Application for Planning Permission

Development: Proposed single storey flat roof extension to the rear of exsisting AGC, including installation of external associated a/c plant and smoking shelter to existing yard area.

Location: 32 London Road Bognor Regis PO21 1PY

SHEET NUMBER
3635(C)02

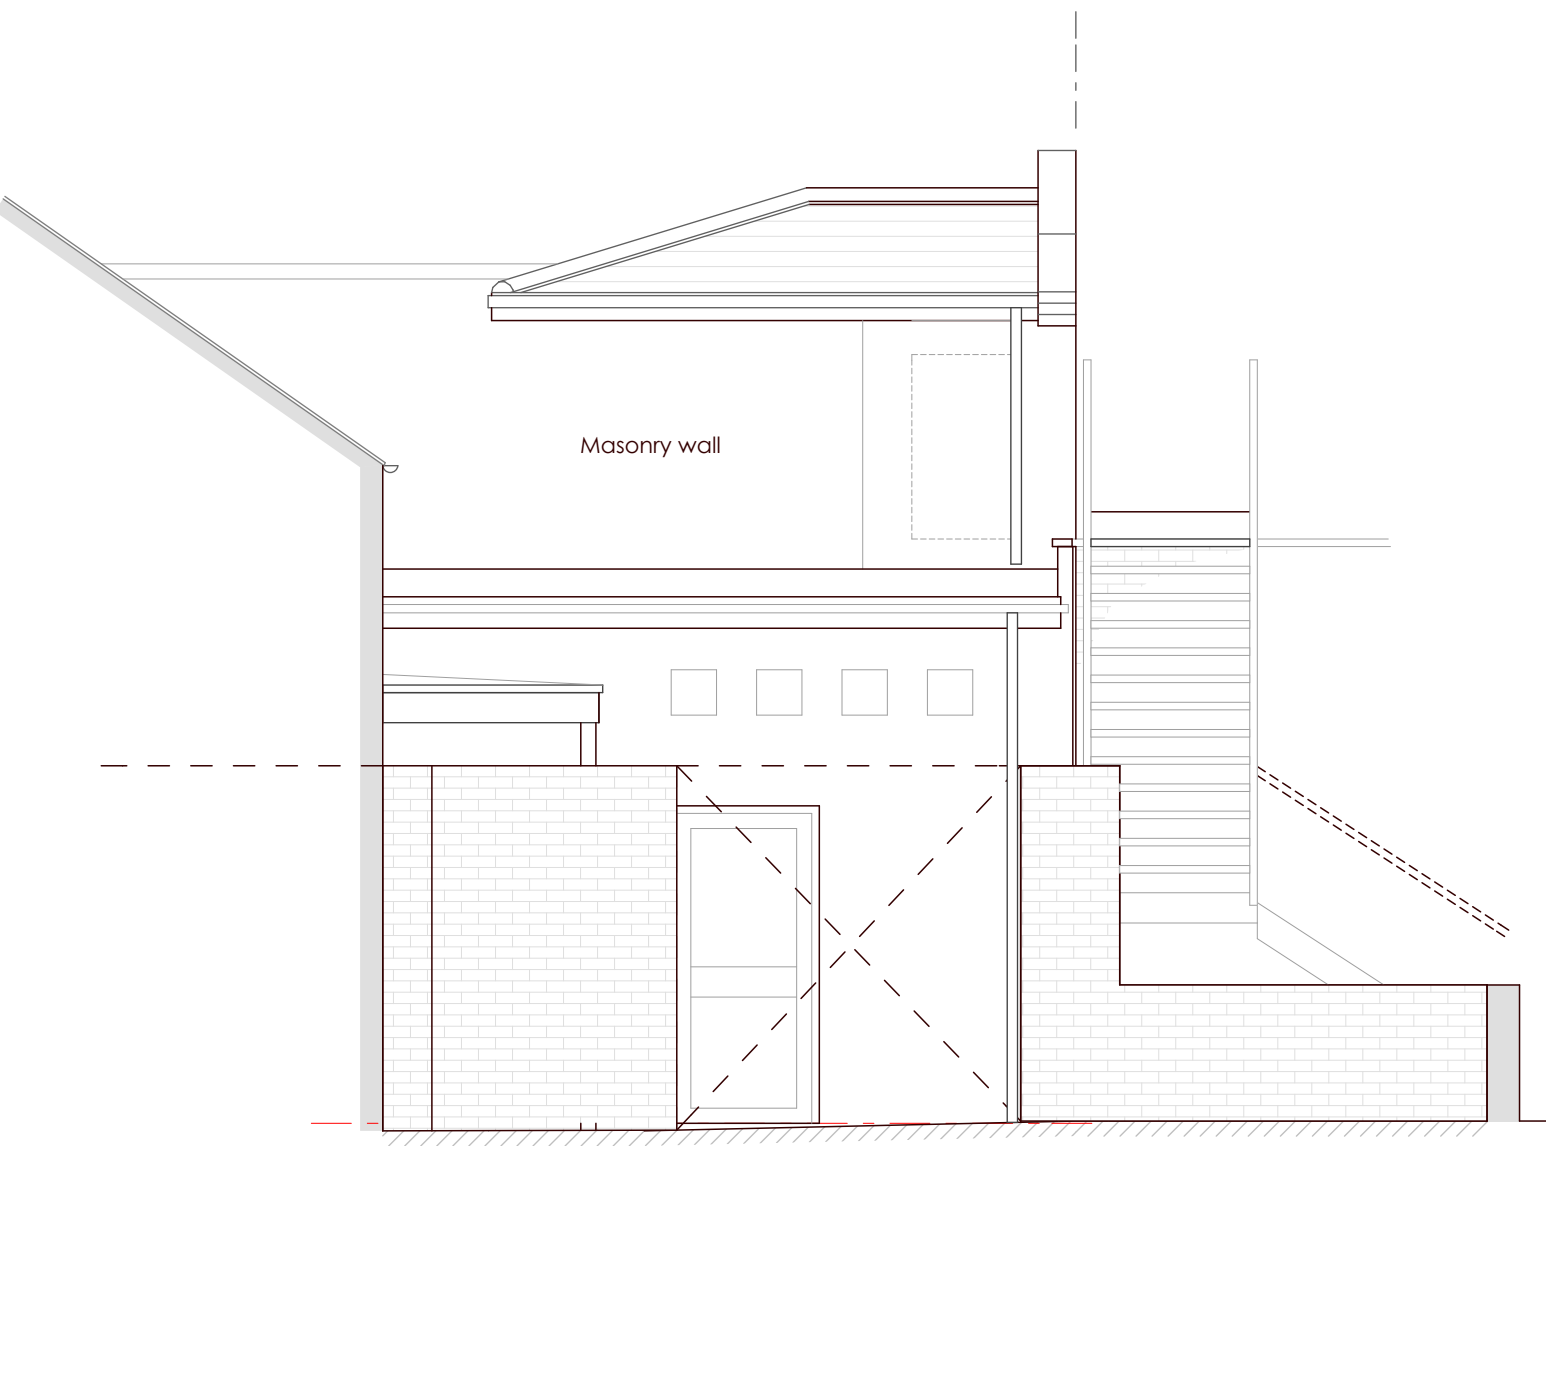
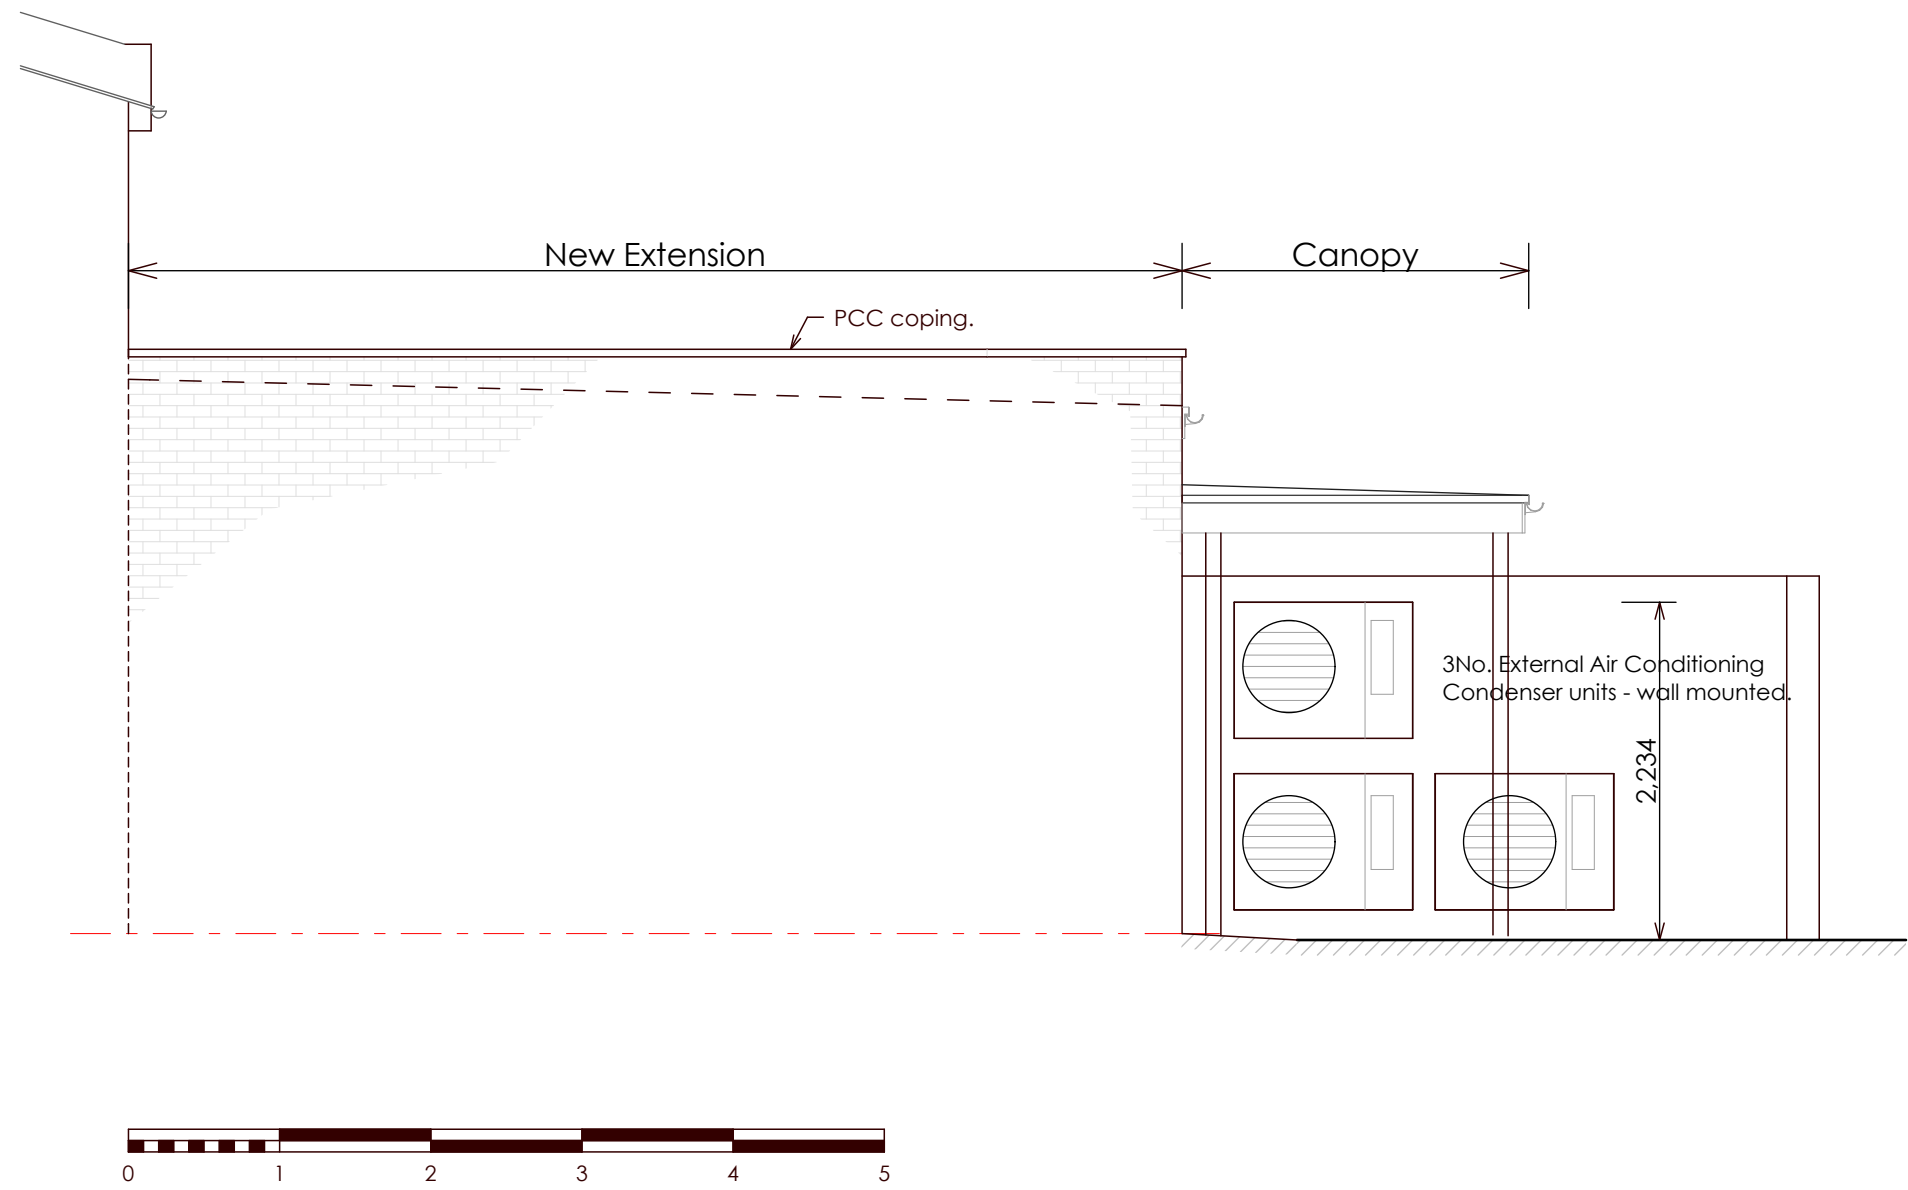
There appear to be 2 x 'West' labels, please amend to show 'East' and 'West'
